Your Ref
FP/145/16/DOC
Our Ref
PLAN-019178
Date
27/07/2017

Proposal: Application for approval of matters reserved by condition imposed under FP/90/13/ relating to 3-foul water drainage, 4-surface water drainage & 8 - landscape scheme.

Site: Site 6 Phase 5A Land north of Felpham PO22 8FX.
FP/145/16/DOC

ARUN DISTRICT COUNCIL FP/145/16/DOC

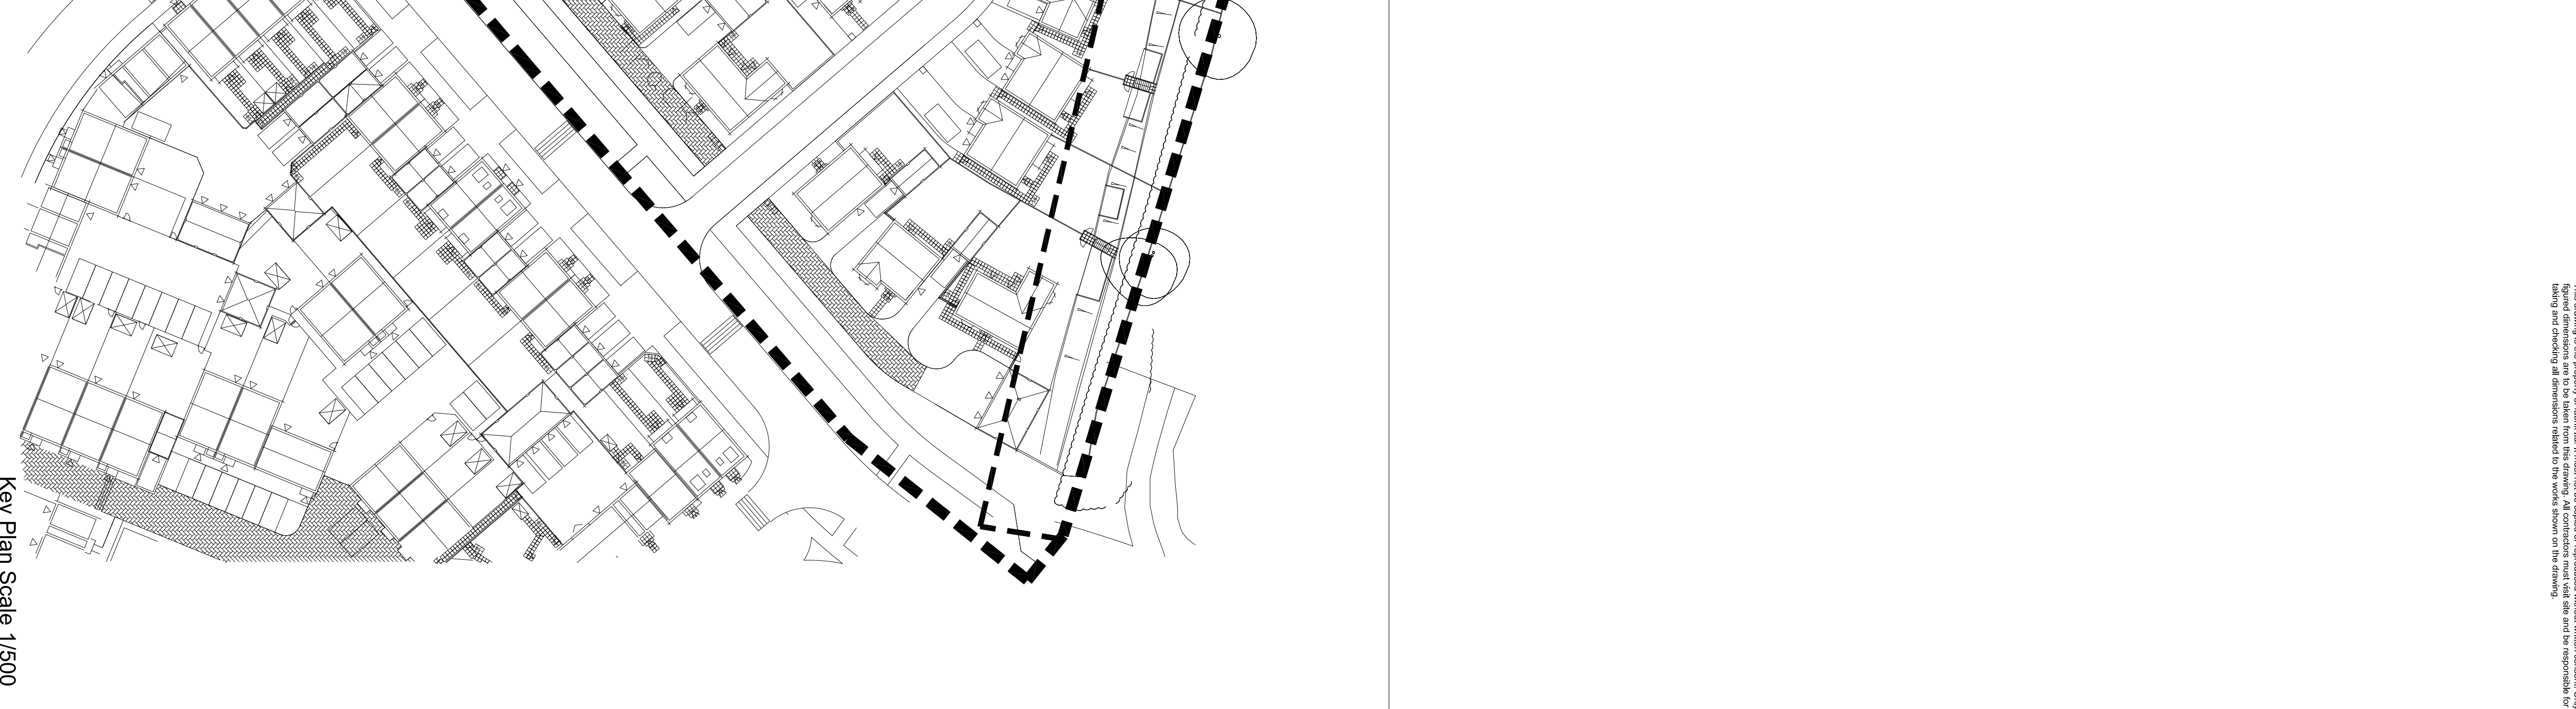
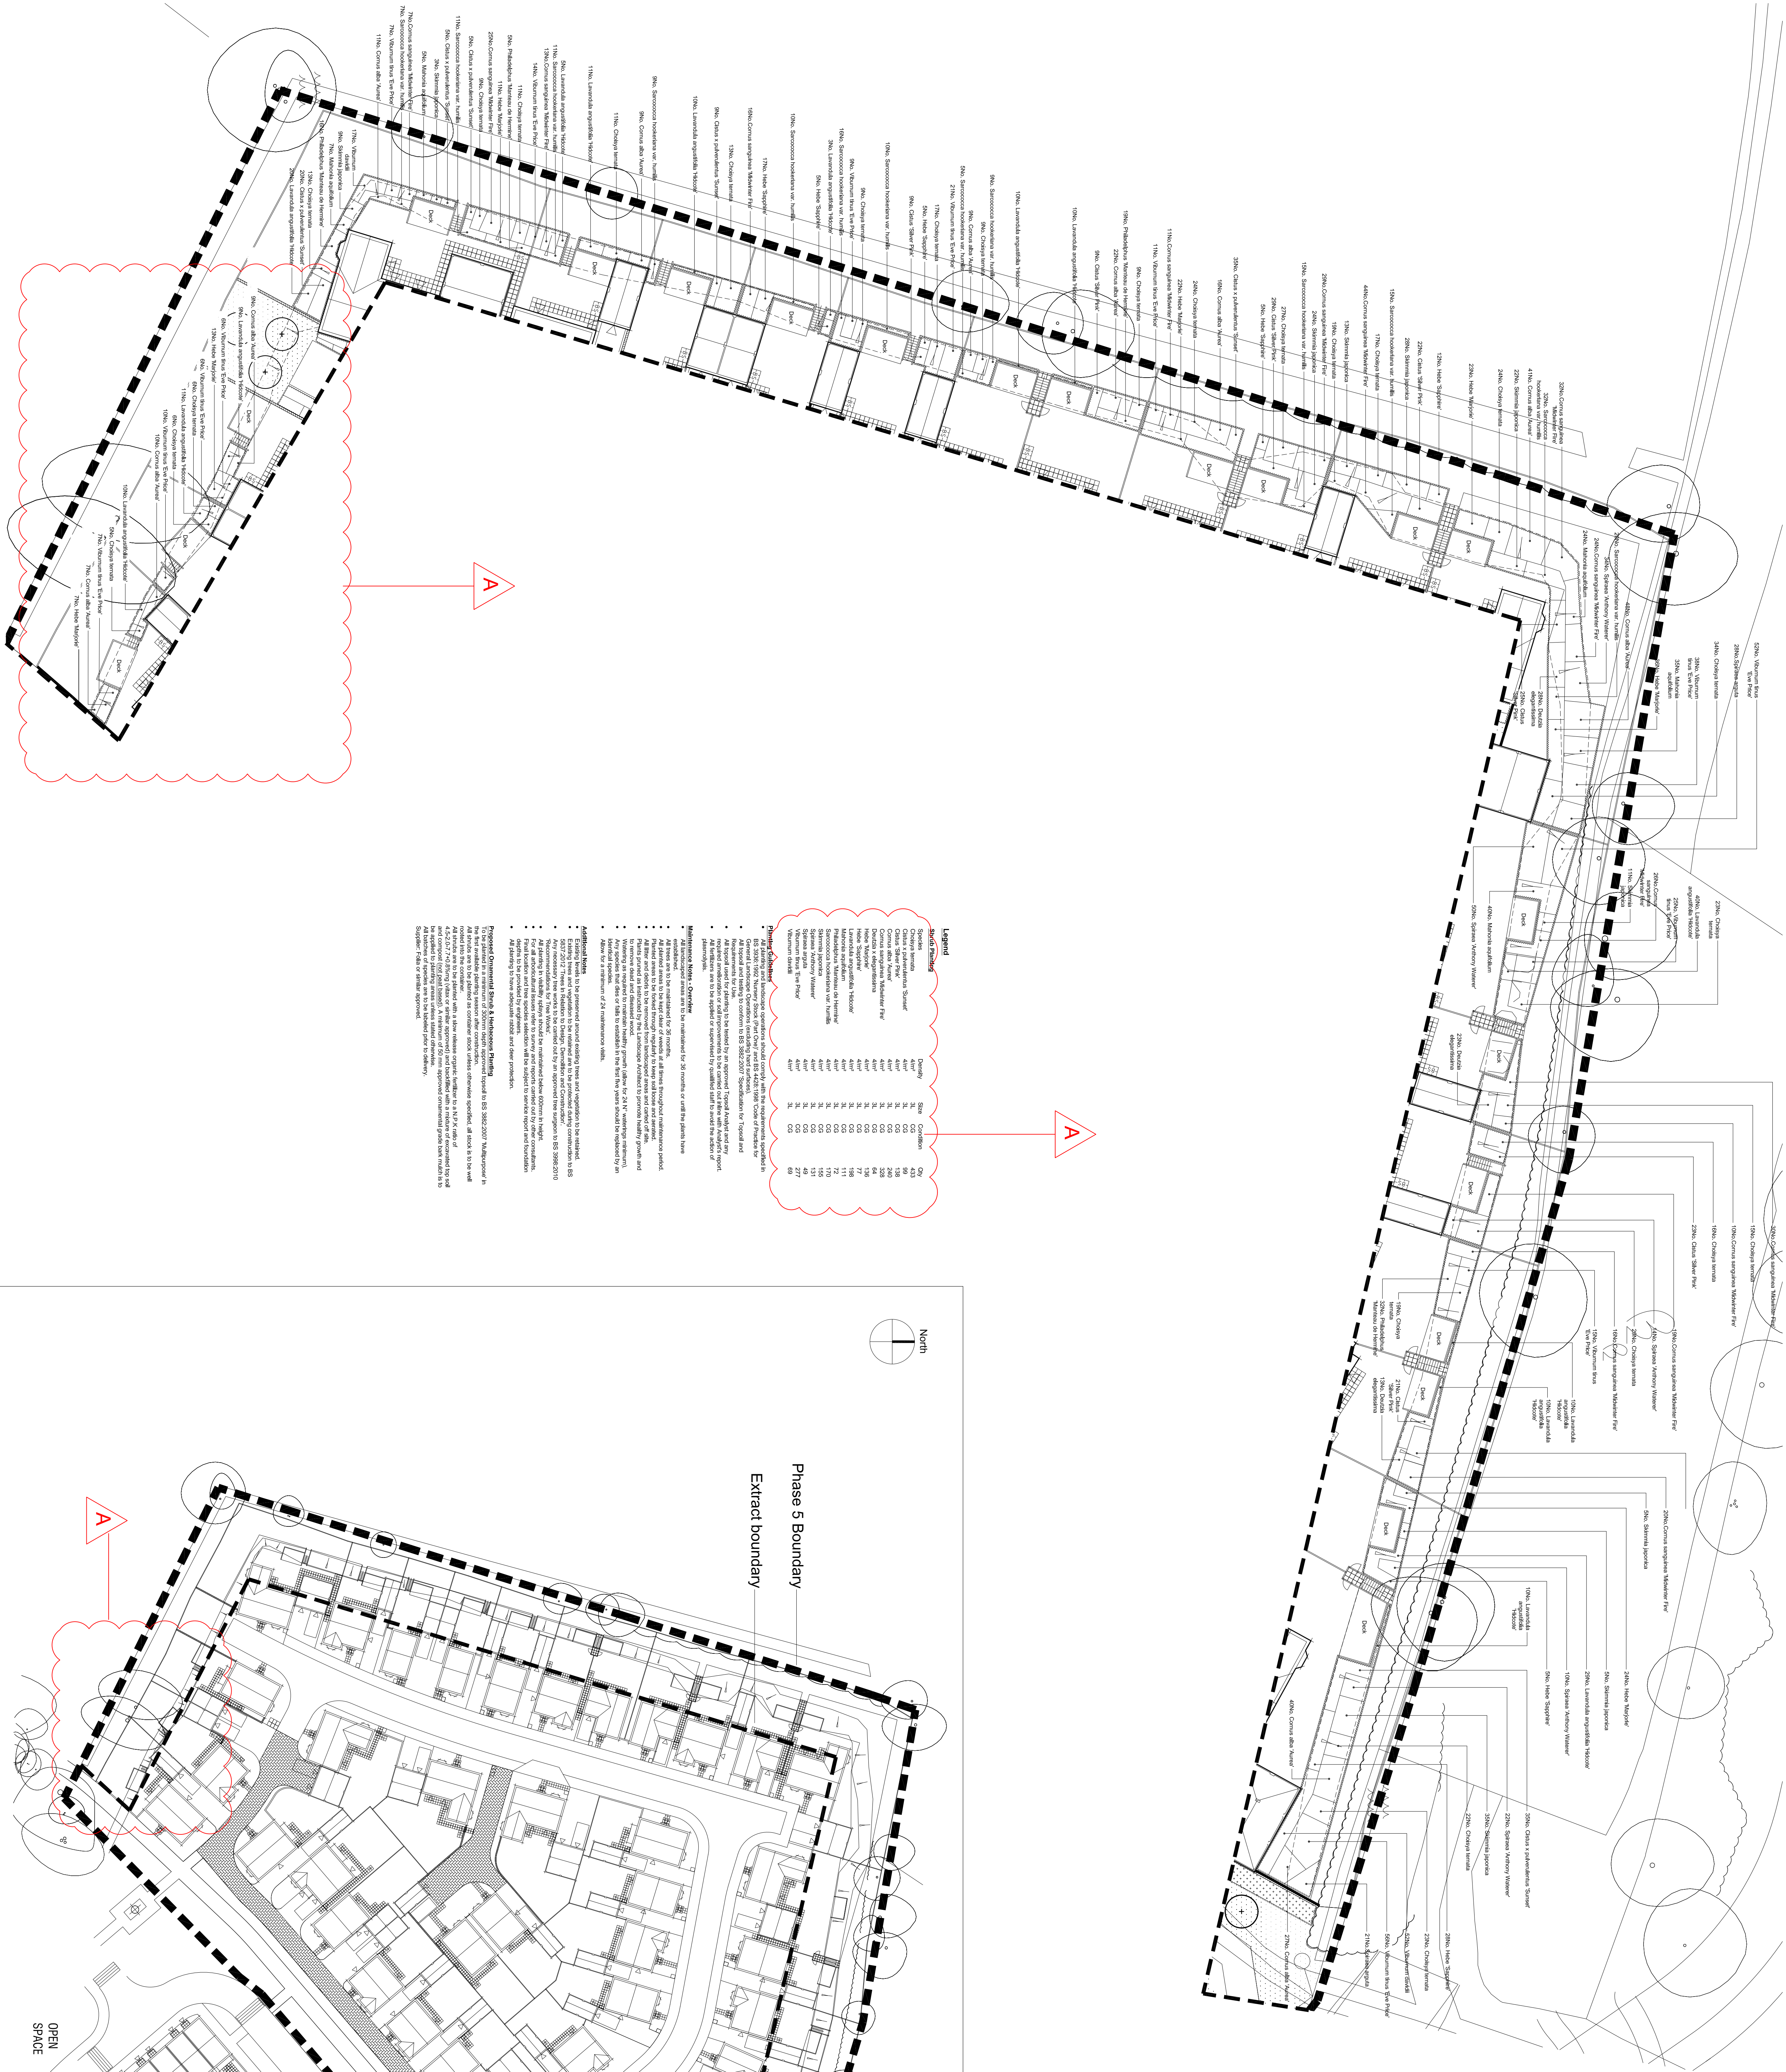
However, the details of watercourse crossing with rising main (DN600) which is considered a critical apparatus, a breach of which could cause major flooding, still has to be agreed With Southern Water (before the construction of this feature).

Reference should also be made to EA requirement regarding depth of cover for pipelines crossing watercourses.
